Response to Submissions and Final Statement of Commitments

23 Scrivener Street, Warwick Farm

Modification to Project Application No. 08_0088

Submitted to
NSW Department of Planning
On Behalf of Independent Print Media Group Pty Ltd

PLAN
TRAIN HANDLING SEQUENCE 1
1:1000

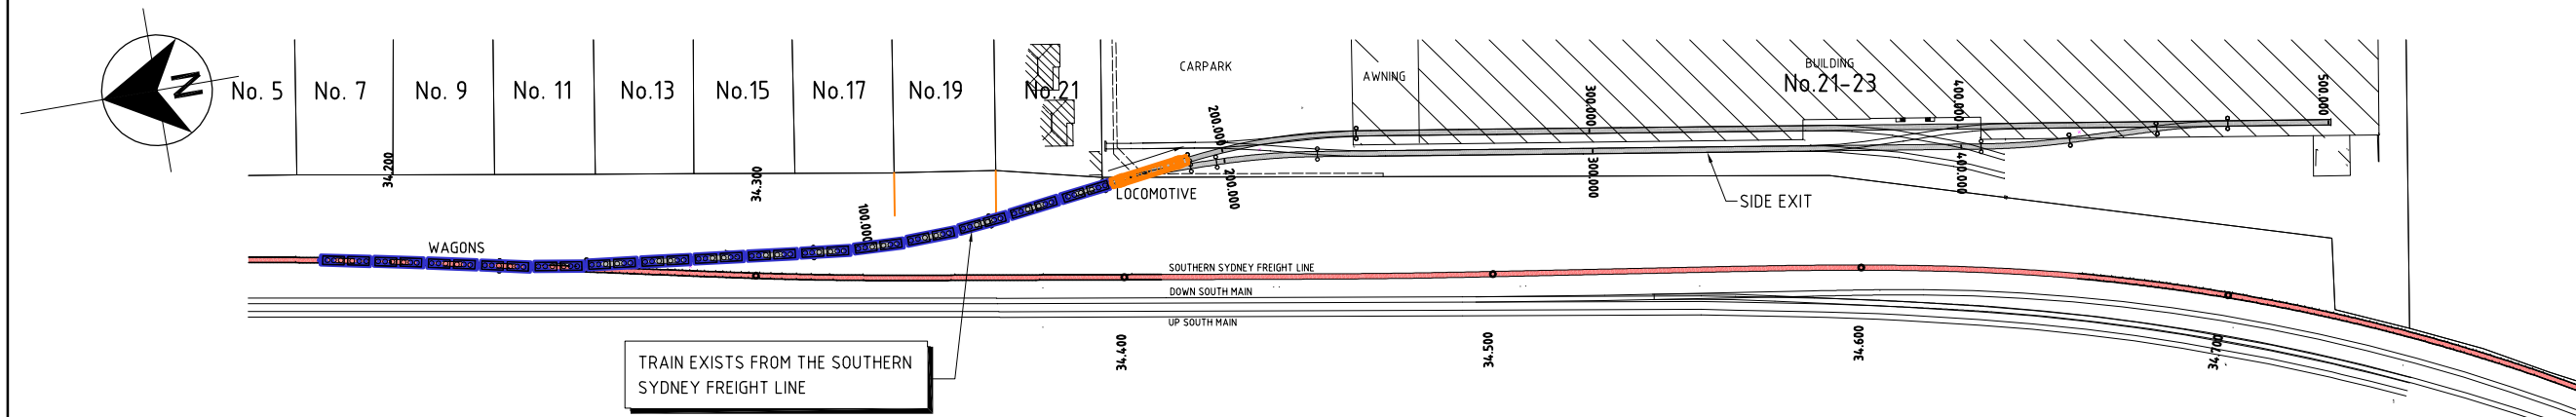
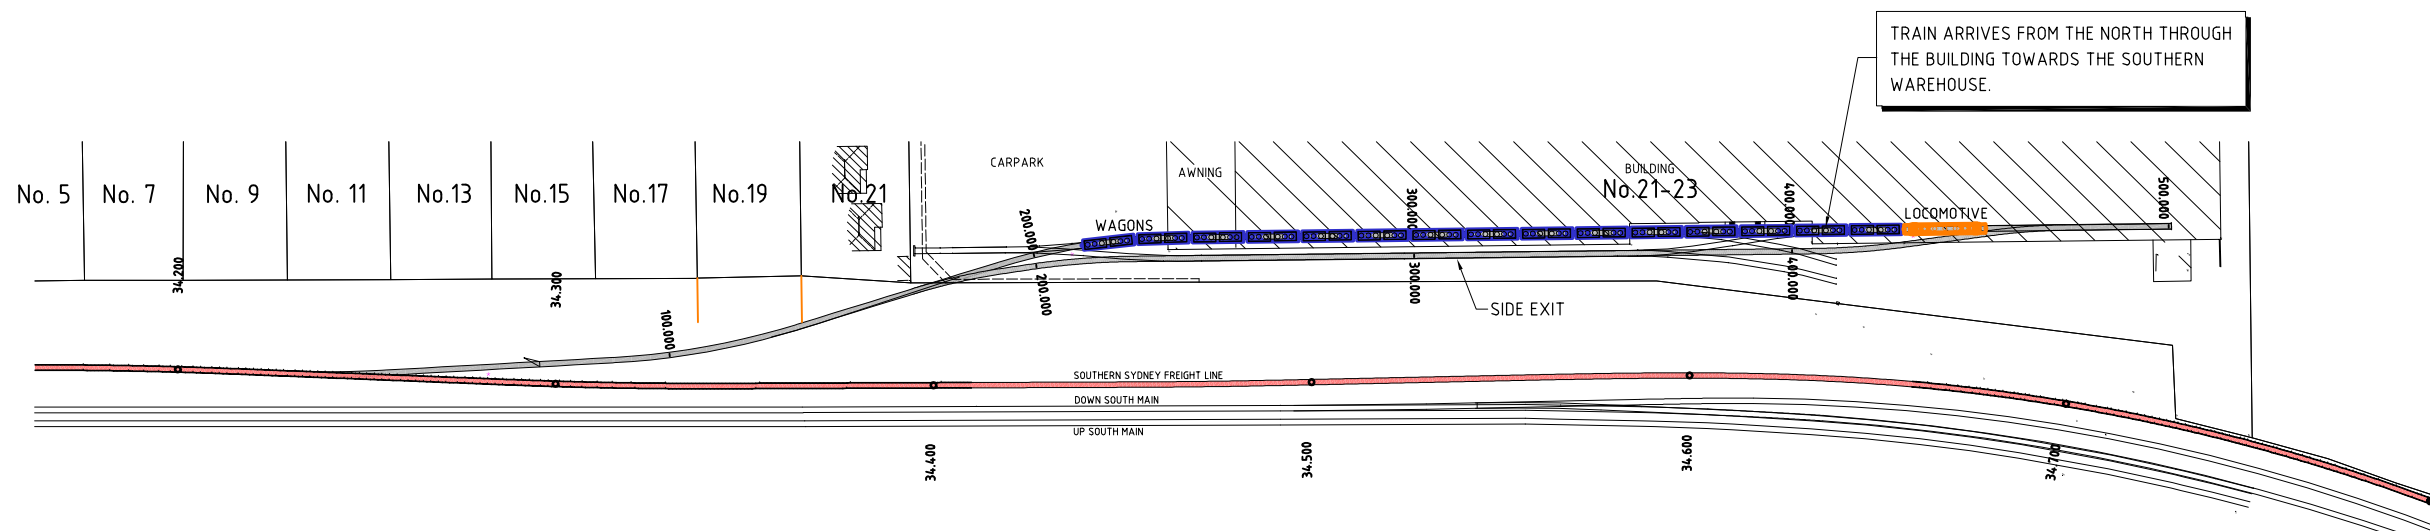
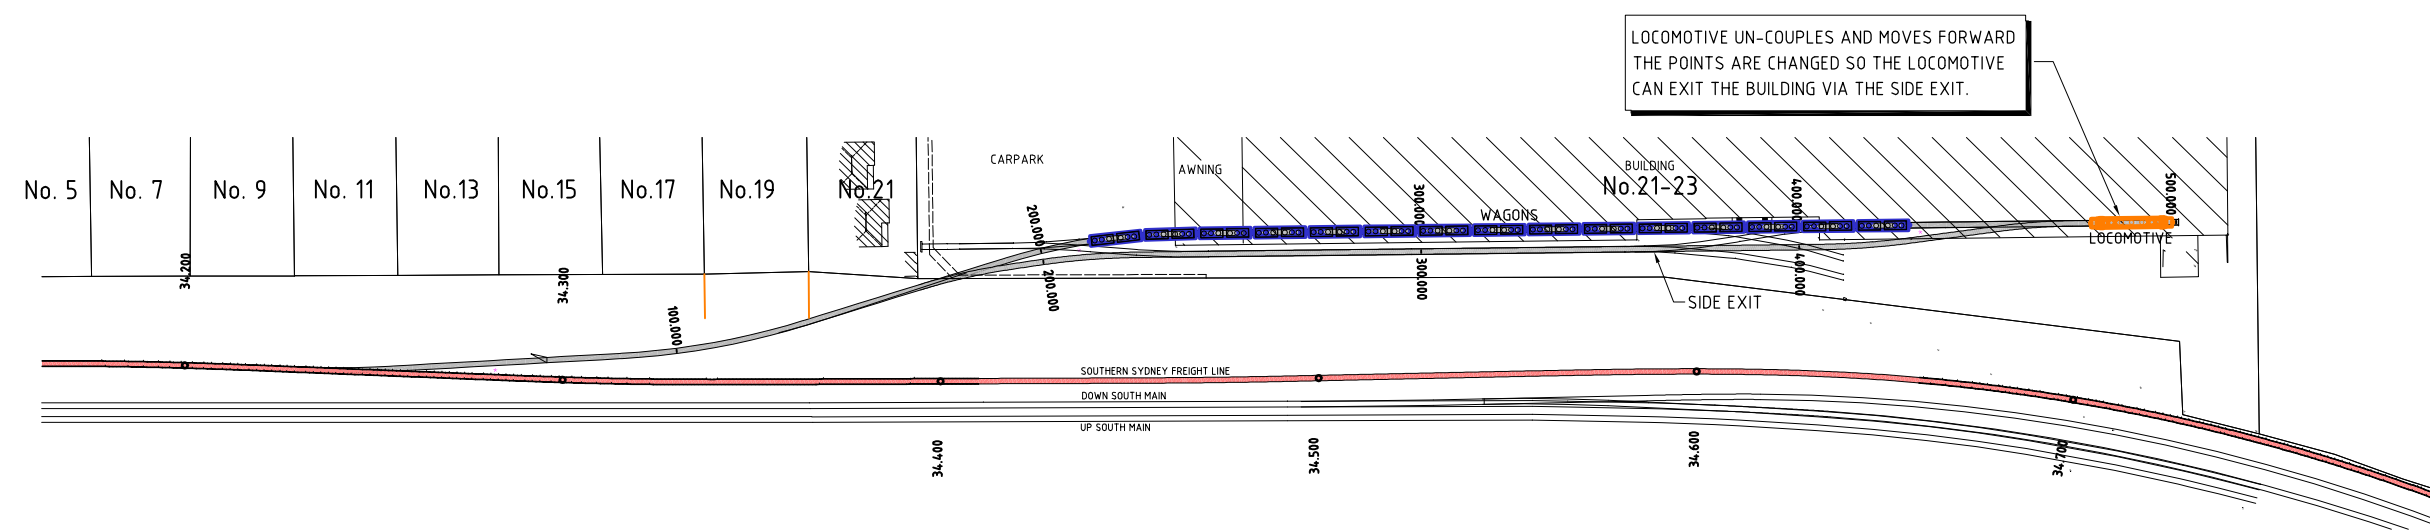
- clarification on the exact distance of the nearest residential boundary from the proposed rail siding; and
- a clear diagrammatical representation of the locomotive arrival and departure procedure.

A diagrammatical representation of the locomotive arrival and departure procedure is located at **Attachment A**.
